Our ref: DOC25/773017-4

**EPA Advice on Submissions Report
Mod 5 Bloomfield Colliery Continuation Project – MP07_0087-Mod-5**

I am writing in response to your request for the NSW Environment Protection Authority (EPA) to review the Submissions Report for proposed Modification 5 to the Bloomfield Colliery Continuation Project at Four Mile Creek, Ashtonfield.

APPENDIX 2A – NOISE ASSESSMENT AREAS AND LOCATIONS

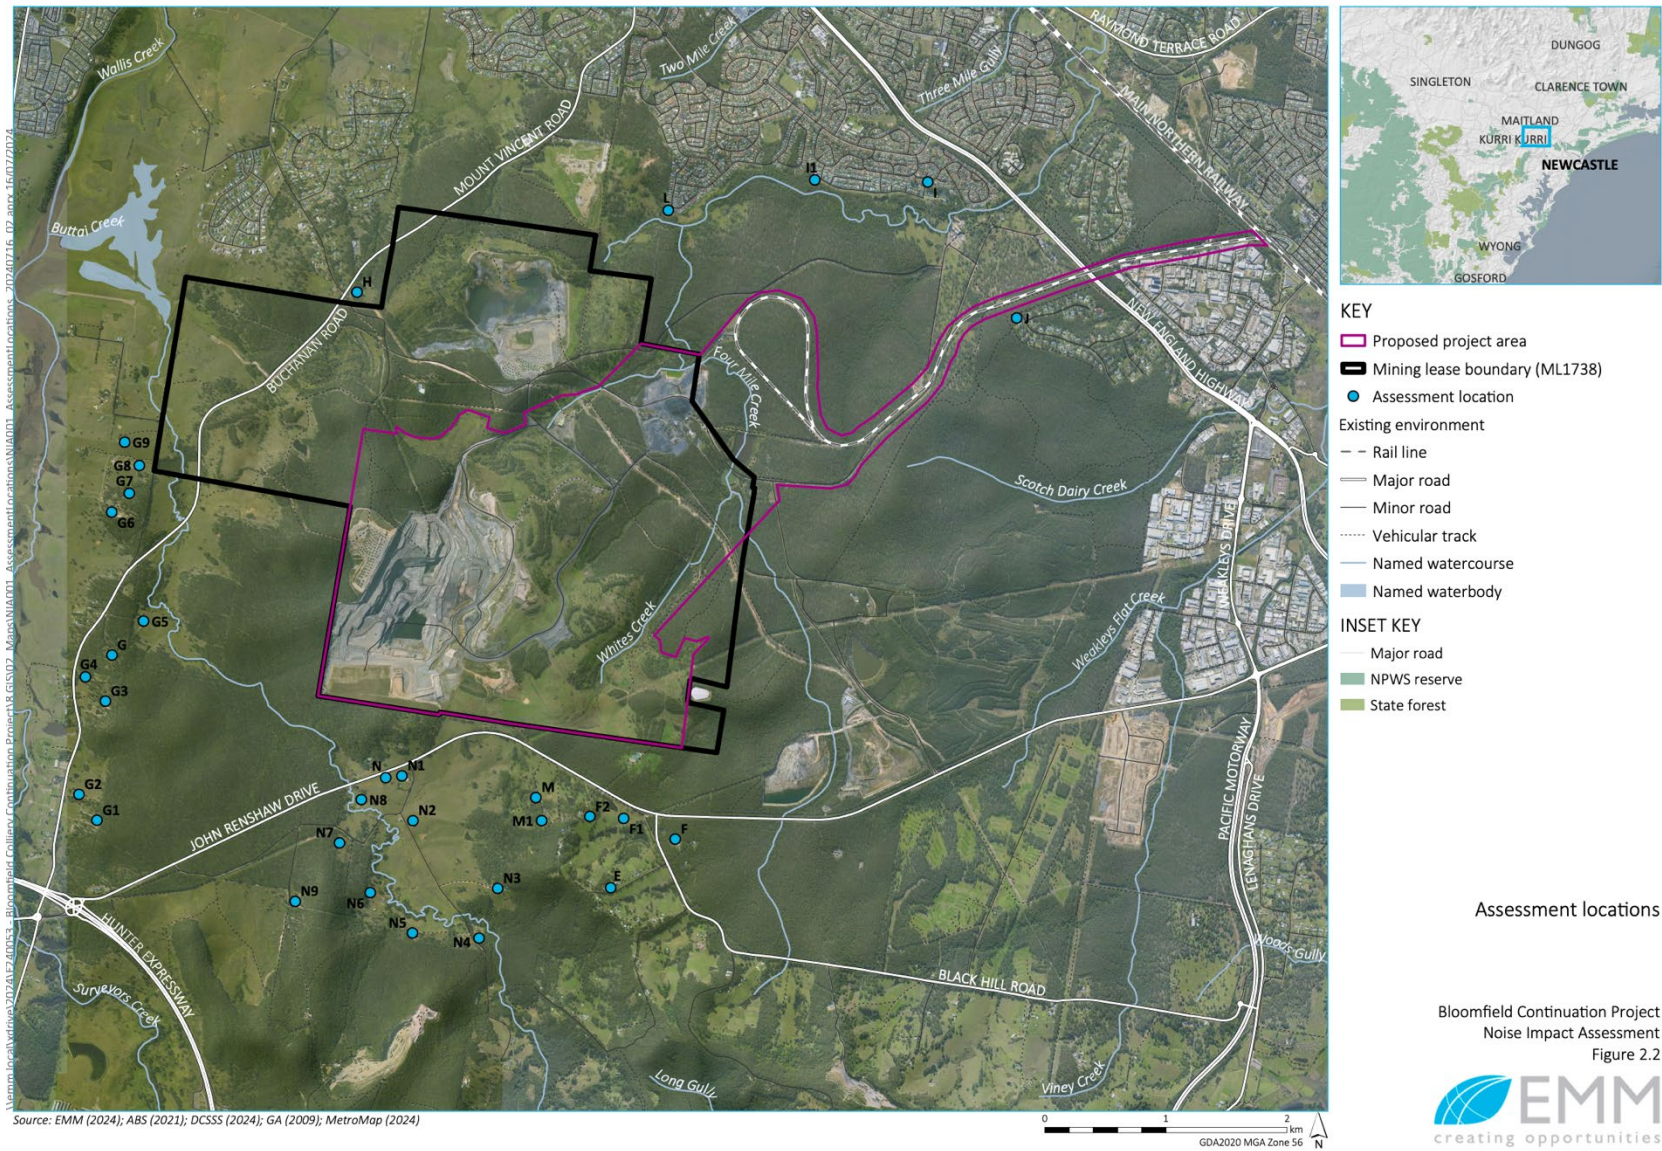
The EPA generally accepts the basis of the proposed criteria as set out in the *Recommended noise criteria* briefing note prepared by ENM with the exception of the daytime criteria for location H (Louth Park).

EPA suggests DPHI ensure that the criteria proposed can be reasonably achieved by the Proponent, noting that its predicted operational noise levels, including feasible and reasonable noise mitigation and management measures, are still up to 4 dBA higher than the limits proposed in some cases.

- Including alternate daytime criteria for location H (Louth Park) in any approval, as detailed in **Attachment A**.
- Seeking confirmation from the Proponent that it can further reduce its operations sufficiently to achieve the noise limits proposed. Further detail on what operational changes can be made to achieve these reductions should be provided.

1. The EPA recommends a daytime noise criteria of 35 dB(A) for location H (Louth Park) instead of the 40 dB(A) proposed by the Proponent. This is based on:
 - (i) the existing highest noise criteria at for both the Bloomfield Project Approval (MP 07_0087) and Condition 1, Schedule 4 of the Abel Project Approval, (MP 05_0136) is 35 dB(A) at Location H; and
 - (ii) the Project is predicted to not exceed 26 dB(A) (excluding operation of the coal preparation plant) during the daytime at location H.
